Our ref : Orsted/Rule 8  
Your ref : EN010080  
Date : 7 November 2018

**Application by Orsted Hornsea Three (UK) Ltd. for an Order Granting Development Consent for the Hornsea Three Offshore Wind Farm**

I write with reference to your letter dated 9 October 2018 in which you set out the Examination timetable and the publication of the Examining Authority's Written Questions and other important information about the Examination. This letter gives Broadland District Council's written responses to the Examining Authority's written questions.

Figure 3.21 Construction Compound Options.

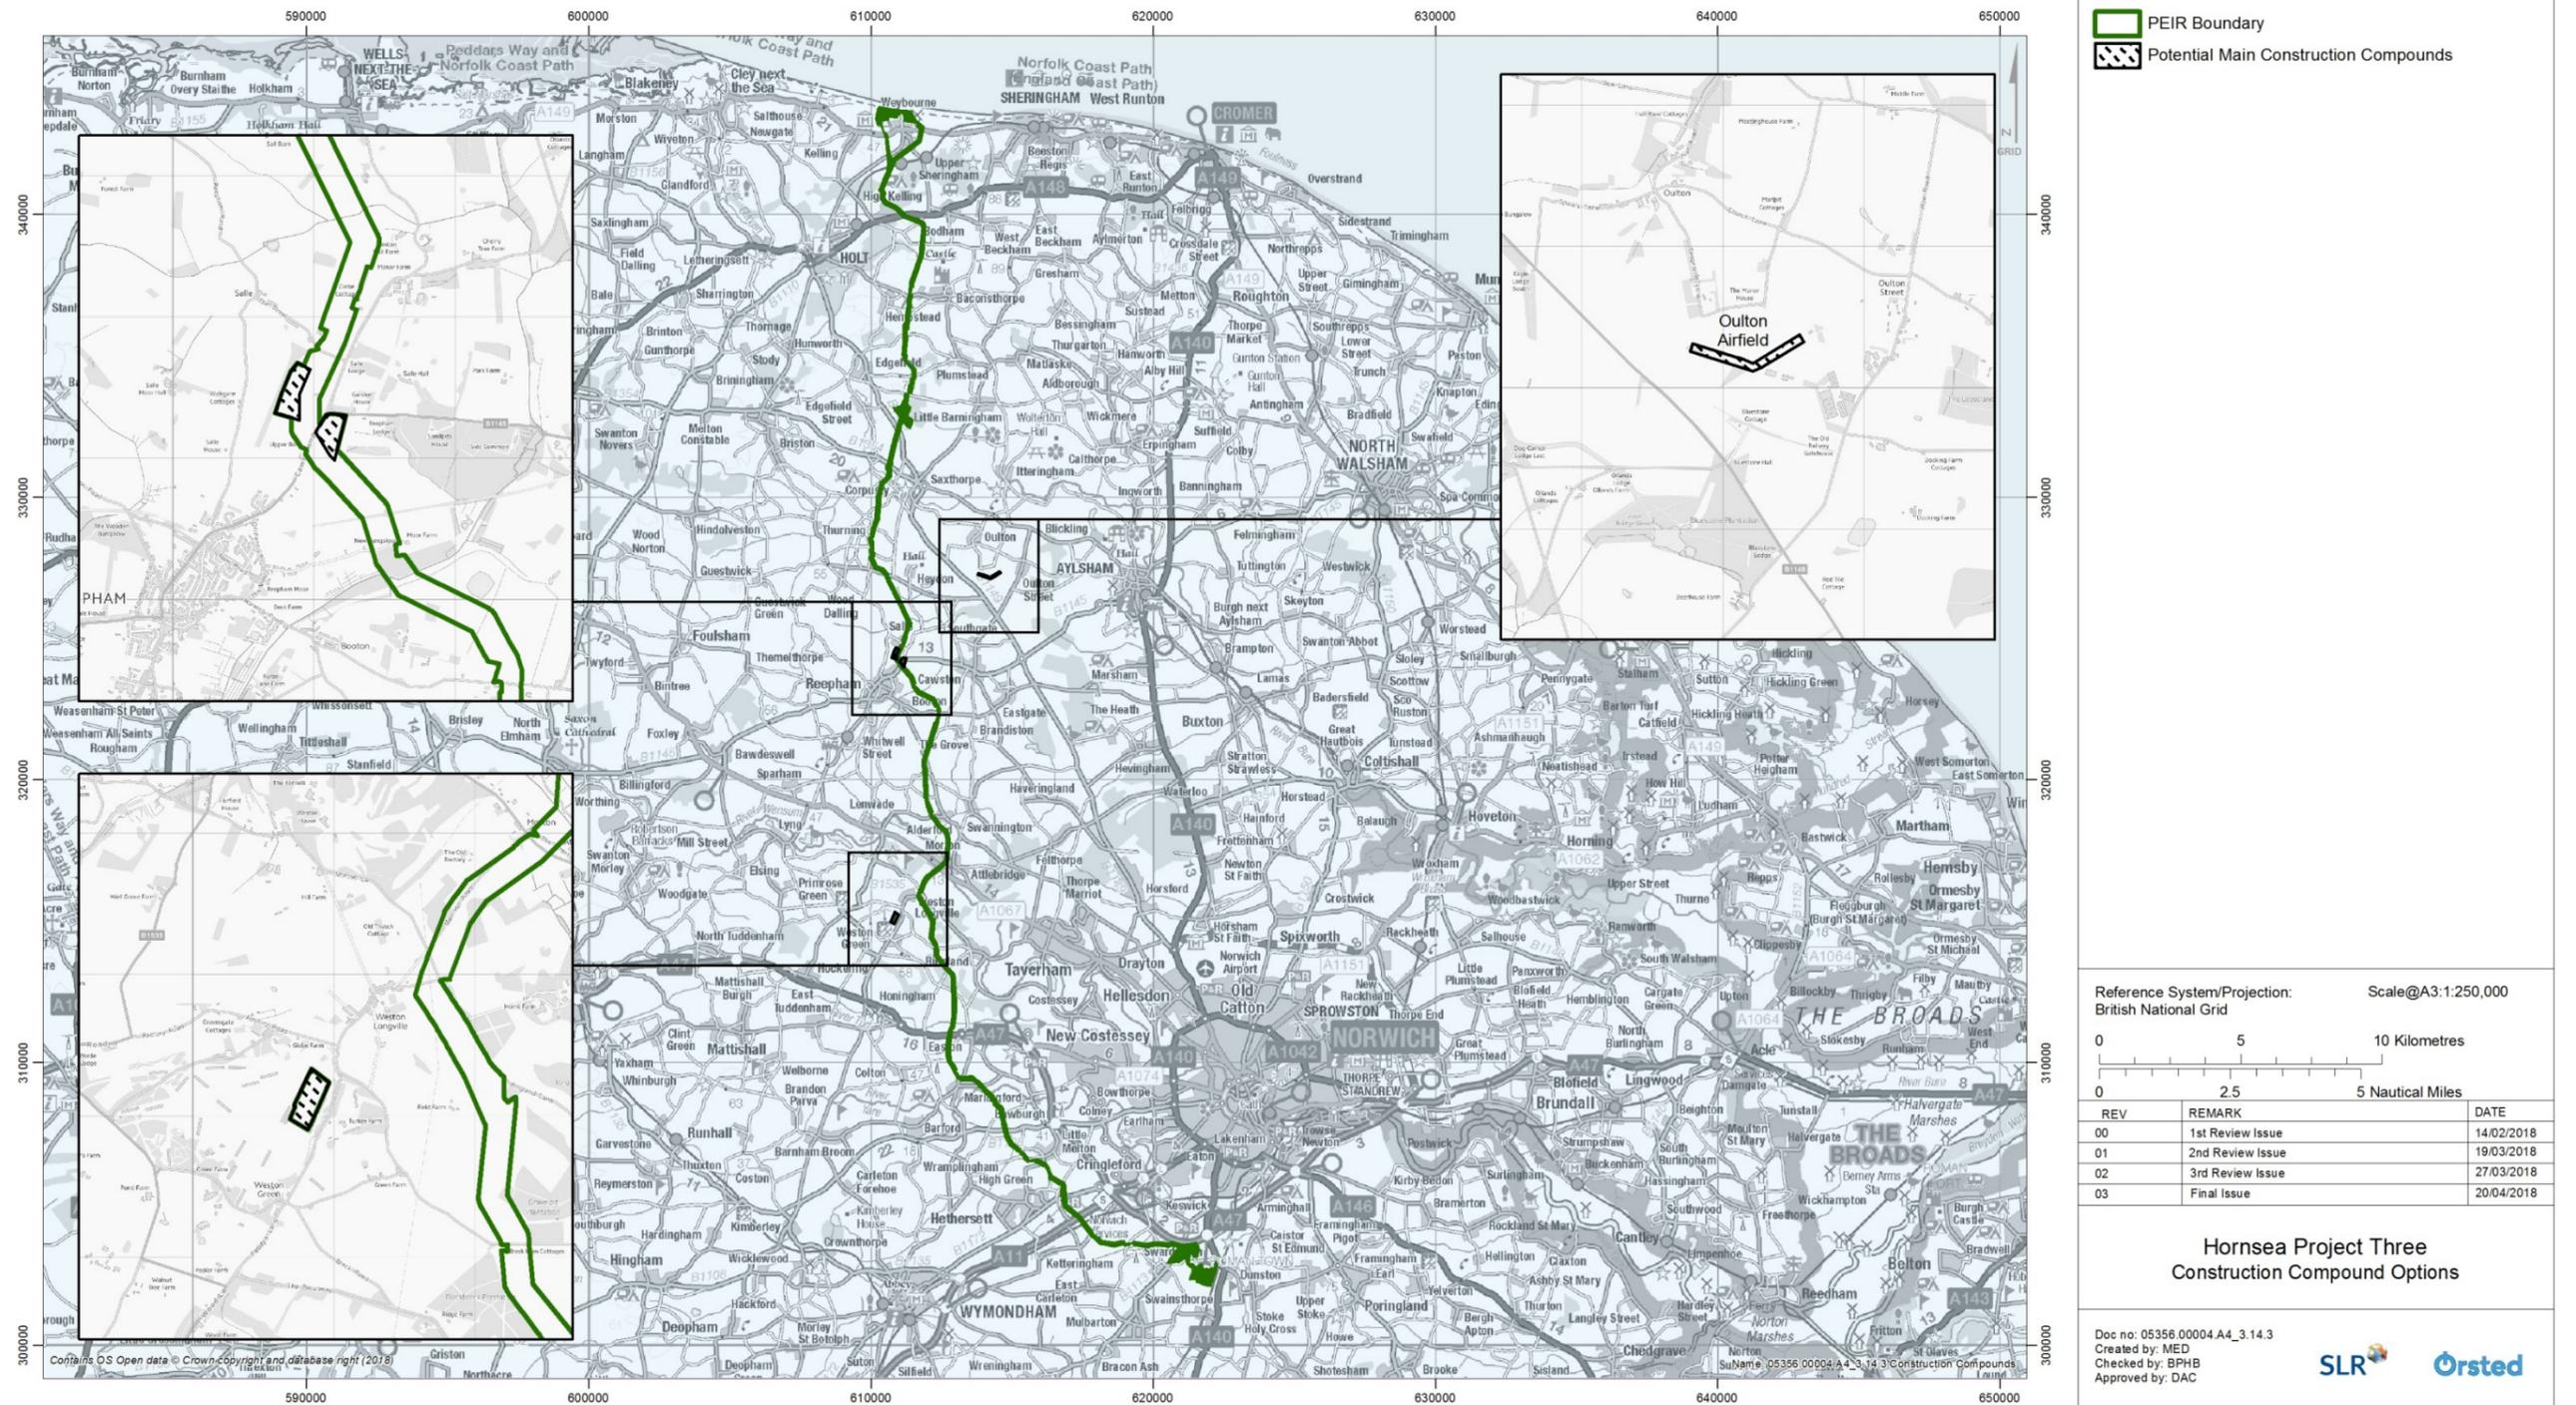
Based on the available information it is considered that the position of the main construction compound at Oulton is unlikely to have a detrimental impact on the setting and significance of the Blickling Conservation Area. However further details in respect of the layout and use of the compound, including fencing and lighting are to be submitted and agreed with the District Council through the final Code of Construction Practice to allow a detailed assessment of these impacts including on heritage assets. In addition, the agreed route of staff and main construction vehicles, together with the likely number of traffic movements associated with these are still to be agreed with the District Council as the Access Strategy progresses – see later responses.

The principles of the OCTMP are acceptable although concern has been expressed about the suitability of the route for staff and heavy construction vehicles in proximity of the main construction compound at Oulton and for this reason an alternative Access Strategy has been requested, the details of which are still to be agreed. Also see response to question Ref: Q1.15.16 below.

The OCoCP is broadly acceptable, however further details in respect of the layout and use of the compound, including fencing, lighting and the source of electricity are to be submitted and agreed with the District Council through the final Code of Construction Practice.

It is considered that the Inspector's decision to dismiss the appeal (PINS ref: APP/K2610/A/14/2212257) is relevant particularly as the proposed route of vehicular access for heavy goods construction vehicles and staff vehicles to and from the main construction compound is along The Street from its junction with the B1149. This is the same route that was proposed for the delivery of maize and grass for the anaerobic digester plant at Oulton Airfield, it is noted that the appeal proposal was to install 6 passing places along the length of The Street and that the harvest period for maize is between September to October and the grass harvest is June to early August. The appeal inspector in describing The Street set out that: *'the carriageway is not wide enough for any vehicle larger than a car to pass any other vehicle except at the existing informal 'passing places'*". He also noted that the area is a *'highly agricultural area, some movement of crops in large vehicles –tractor/trailer combinations, tankers or other HGV – is normal and to be expected by other road users'*. He concluded on the highway safety and convenience issue that the appeal proposal *'would be likely to result in harm to highway safety and convenience'* and that *'despite the proposed highway works, the cumulative impacts of the proposed development would be severe'*. In terms of living conditions of local residents the appeal inspector concluded that *'the proposed development would, on balance, be likely to result in material harm to the living conditions of residential occupiers of The Old Railway Gatehouse with reference to noise and disturbance'*. No other unacceptable impact on residential amenities was identified as arising from the appeal proposal.
